**Gatwick Northern Runway Project DCO (Project Reference: TR020005)**

**Deadline 7 Submission (15 July 2024)**

**Joint Surrey Councils – Surrey County Council (Ref. 20044665), Mole Valley Borough Council (Ref: 20044578), Reigate and Banstead Borough Council (Ref. 20044474) and Tandridge District Council (Ref: 20043605)**

#### North and South Terminal Roundabouts BAU Improvement Scheme Plans (REP6-012)

Title
Gatwick Business as Usual (BaU) Signalisation Scheme Concept Design APFP Regulations 5(2)(q) - Sheet 1 Highway Layout Plans - North Terminal

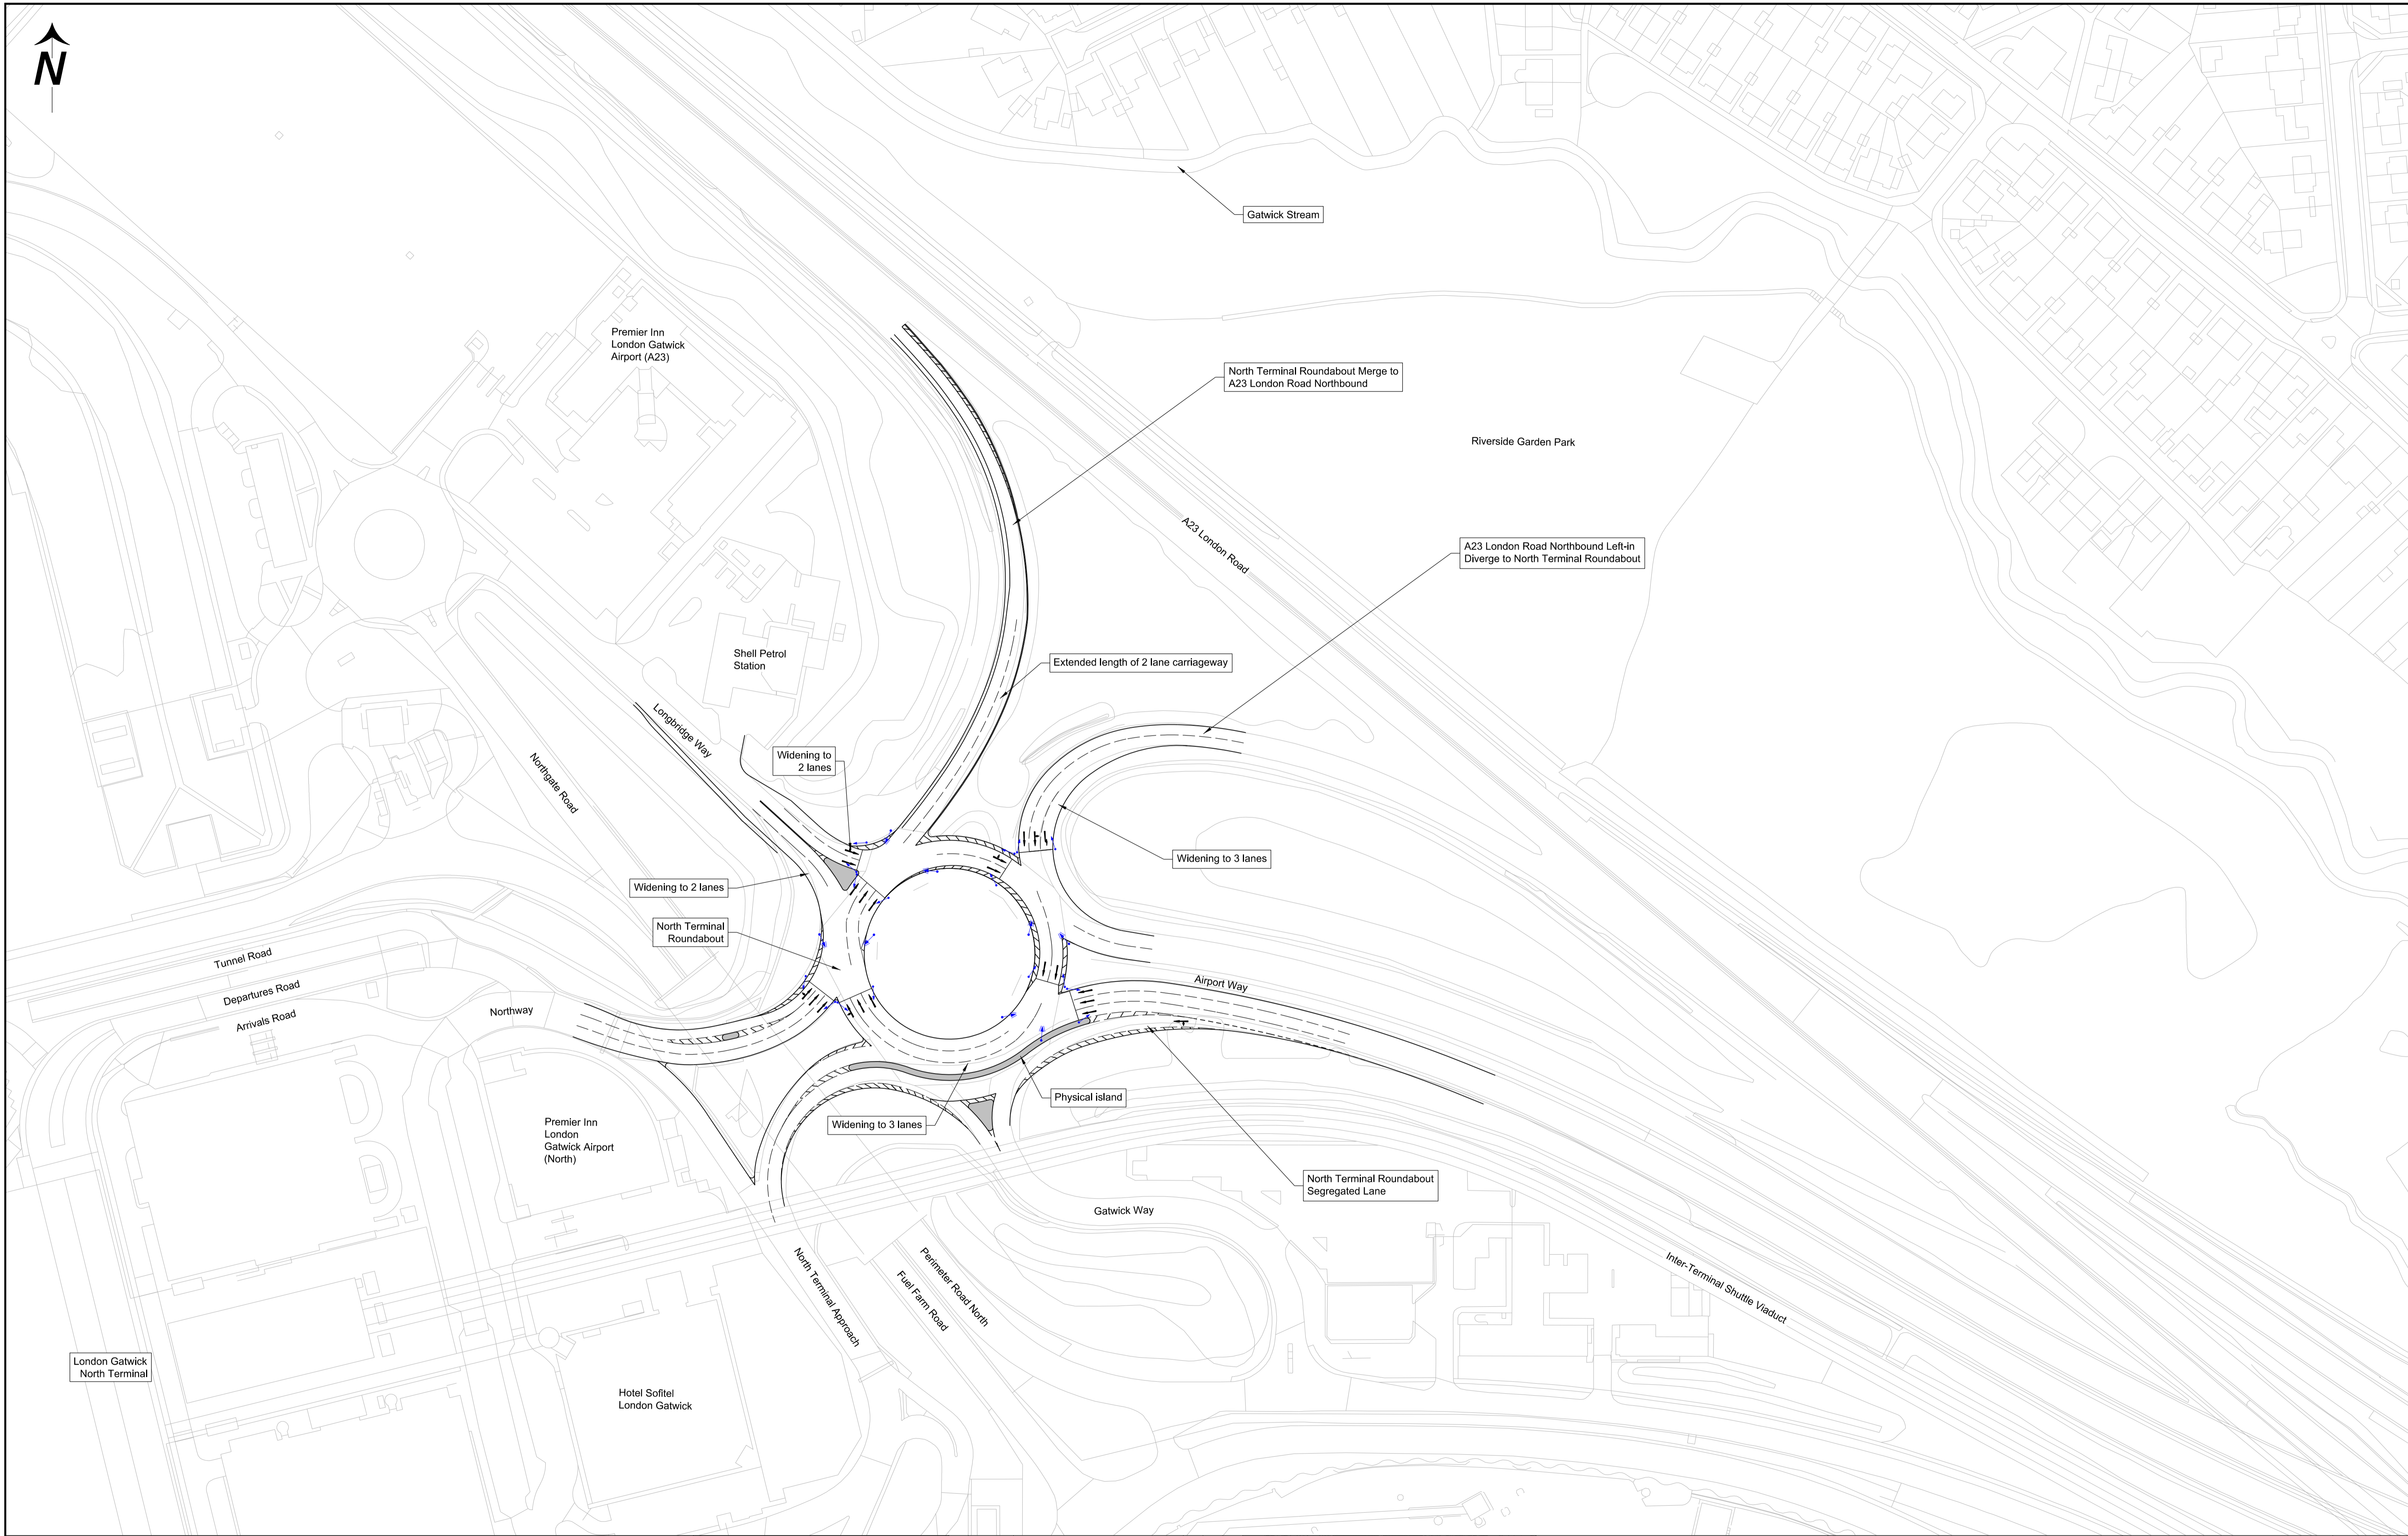
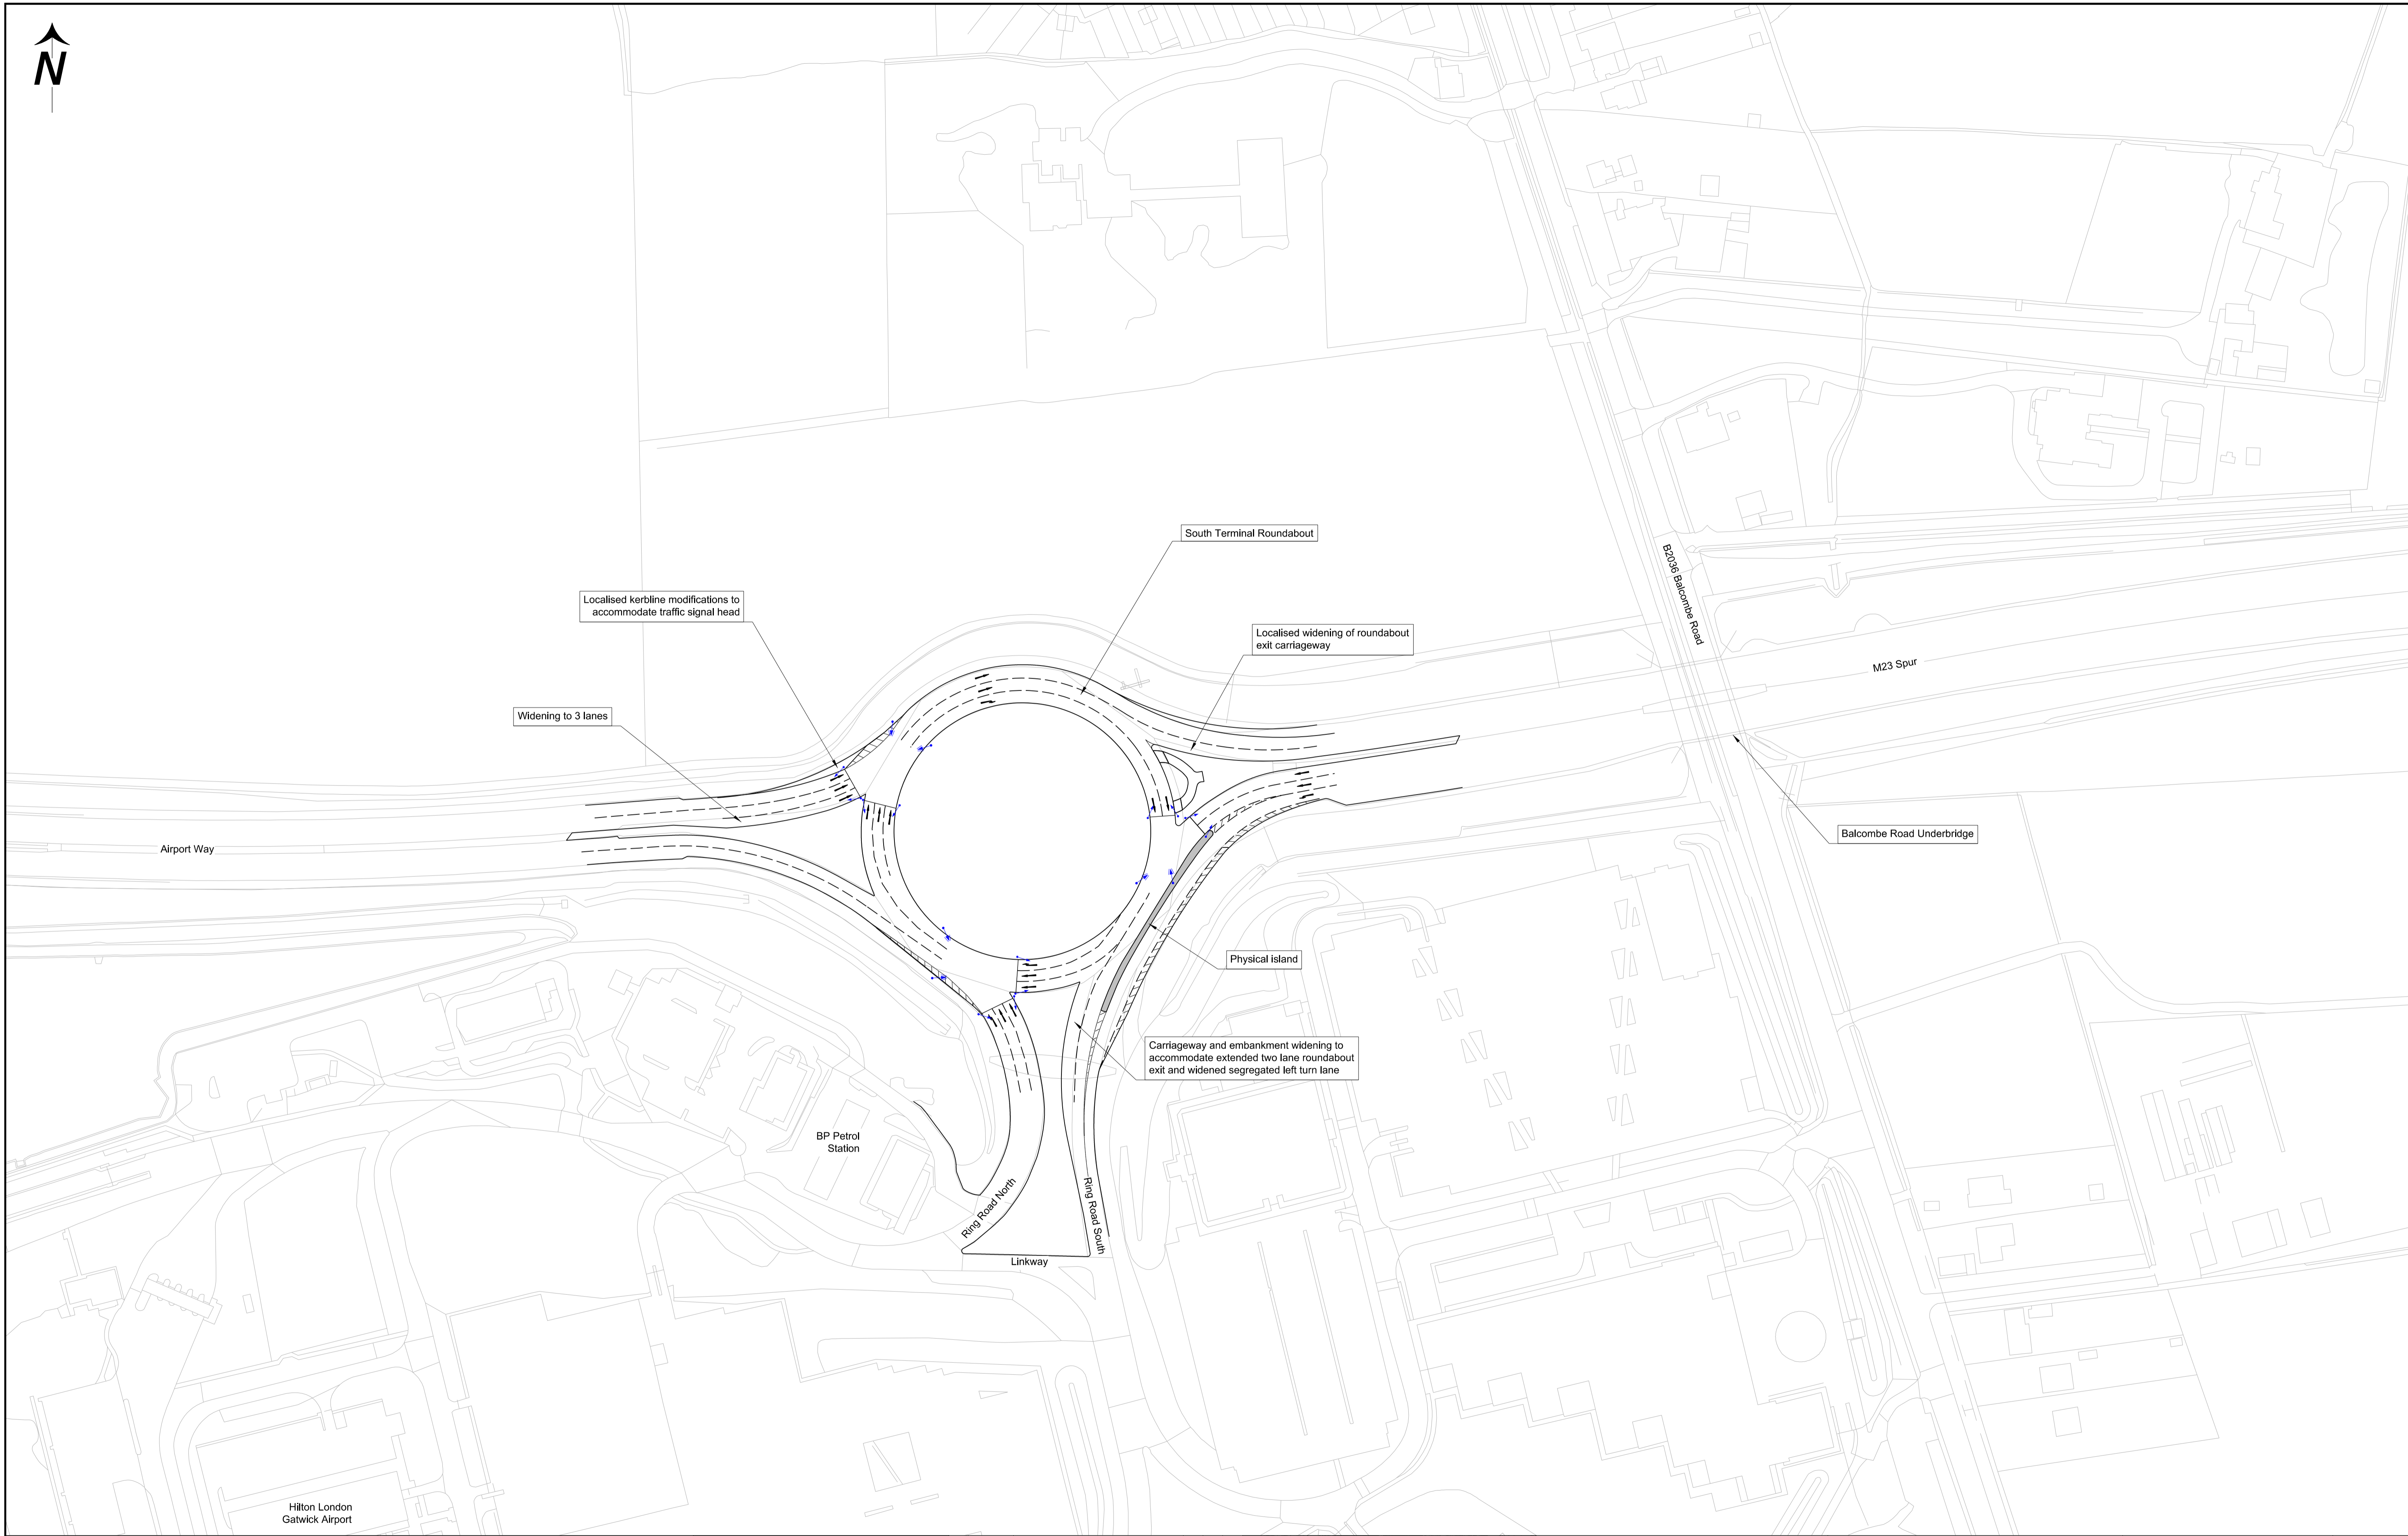
16. Although the North and South Terminal Roundabouts are beyond Surrey’s boundary, the JSCs would support pedestrian and cycle crossings on the design layouts to enable safe active travel around the airport. However, these would be most beneficial/should be provided as part of a wider active travel network rather than standalone features.
